WEST SUSSEX COUNTY COUNCIL CONSULTATION

TO:	Arun District Council FAO: Mrs A Gardner
FROM:	Highways, WSCC
DATE:	30/08/2018
LOCATION:	14, Baldwin Close, Middleton On Sea, Bognor Regis, PO22 6RQ
SUBJECT:	M/99/18/PL 1 No. 2-bedroom dwelling.
DATE OF SITE VISIT:	N/A
RECOMMENDATION:	☒ Advice ☐ Objection ☐ Modification ☐ No Objection ☐ More Information ☐ Refusal
S106 CONTRIBUTION TOTAL:	£N/A

This proposal is for the erection of a 2 bedroom dwelling on land to the south of 14 Baldwin Close. Baldwin Close is an unclassified, no-through residential road subject to a speed limit of 30mph.

PROPOSED GARDEN PLAN 1:200

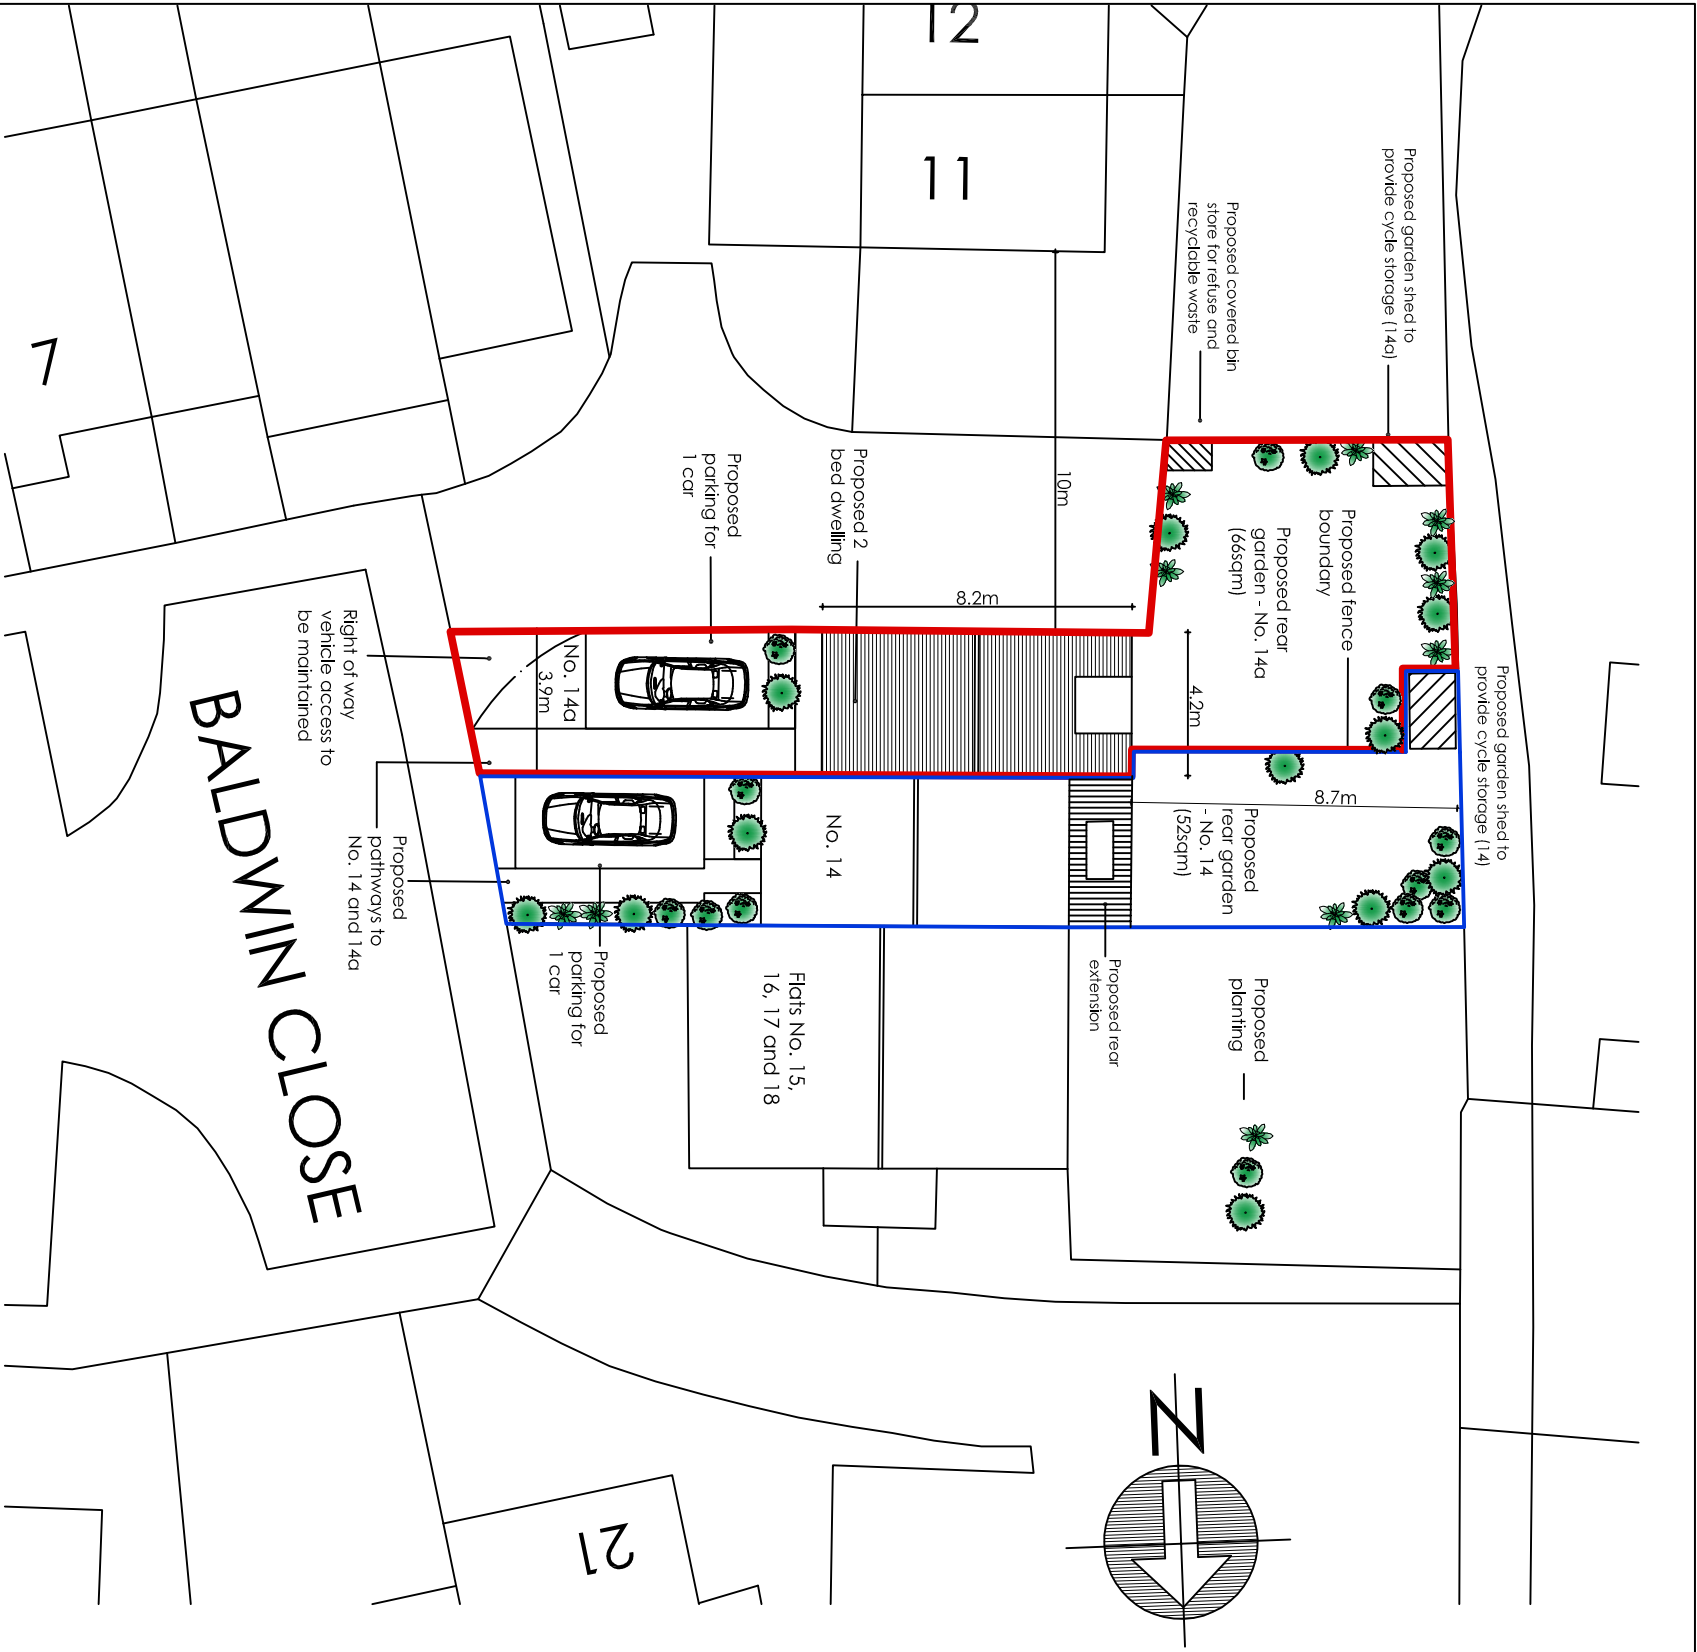
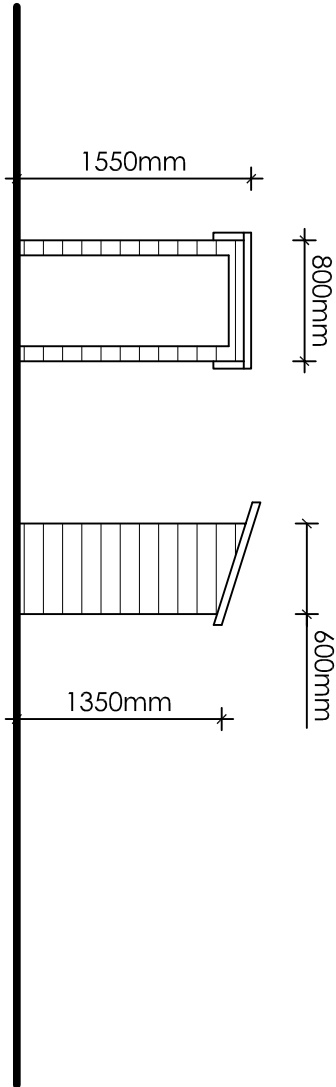
The site is located within walking distance of bus stops which provide access into Bognor Regis, Littlehampton, Chichester and further afield. The site is within walking distance of a local Primary School, doctor's surgery and convenience store. Cycling is a viable option in this vicinity and the applicant has proposed secure covered cycle storage for both the proposed and existing dwellings in order to encourage sustainable transport methods and reduce reliance upon the private car.

No part of the development shall be first occupied until covered and secure cycle parking spaces have been provided in accordance with the approved plan.

SITE PLAN 1:500

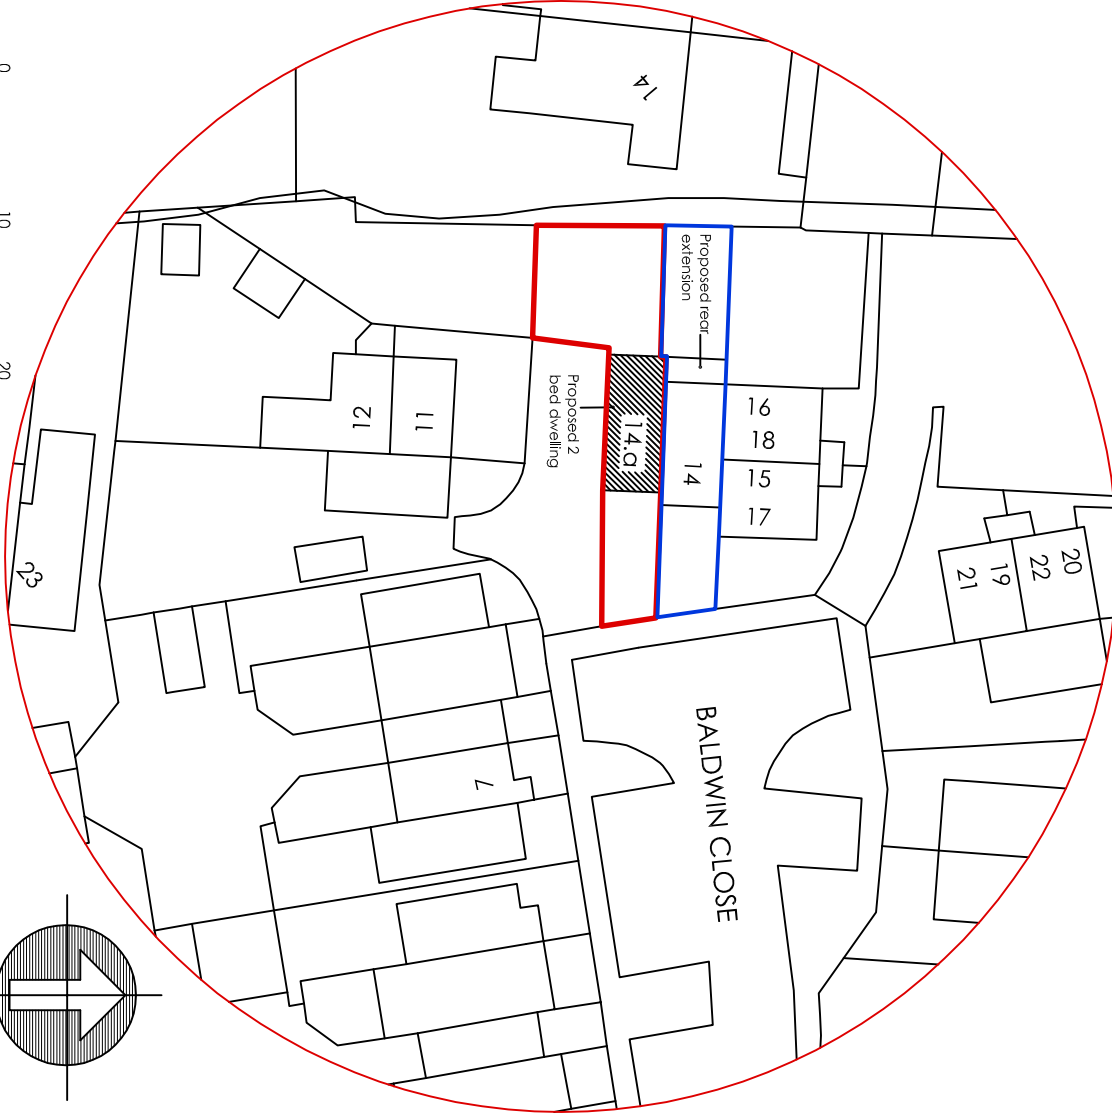
The proposed dwelling will utilise the existing vehicular access onto Baldwin Close. The application form has not indicated that a new vehicular access will be required as result of the application; however the proposed plans demonstrate that a new vehicular crossover (VCO) will be required to serve the existing dwelling. Details of the proposed new VCO to serve 14 Baldwin Close can be secured via condition. A licence will be required for the VCO and must be constructed to a specification agreed with the Local Highway Engineer.

The applicant proposes one parking space per dwelling, to be provided on the site frontage. These spaces meet the minimum specifications of 2.4 x 4.8m as set out in Manual for Streets (MfS). The WSCC parking demand calculator expects that a minimum of two parking spaces will be required per dwelling in this location. The Planning Authority may wish to consider the potential impacts of this development on on-street car parking from an amenity point of view. A turn on site would be preferable although this is clearly not achievable within the site constraints. Neighbouring properties share similar arrangements without evidence of safety concern.

No part of the development shall be first occupied until such time as the vehicular access to 14 Baldwin Close has been constructed in accordance with plans and details submitted to and approved in writing by the Local Planning Authority.

No part of the development shall be first occupied until the car parking spaces have been constructed in accordance with the approved plan. These spaces shall thereafter be retained at all times for their designated use.
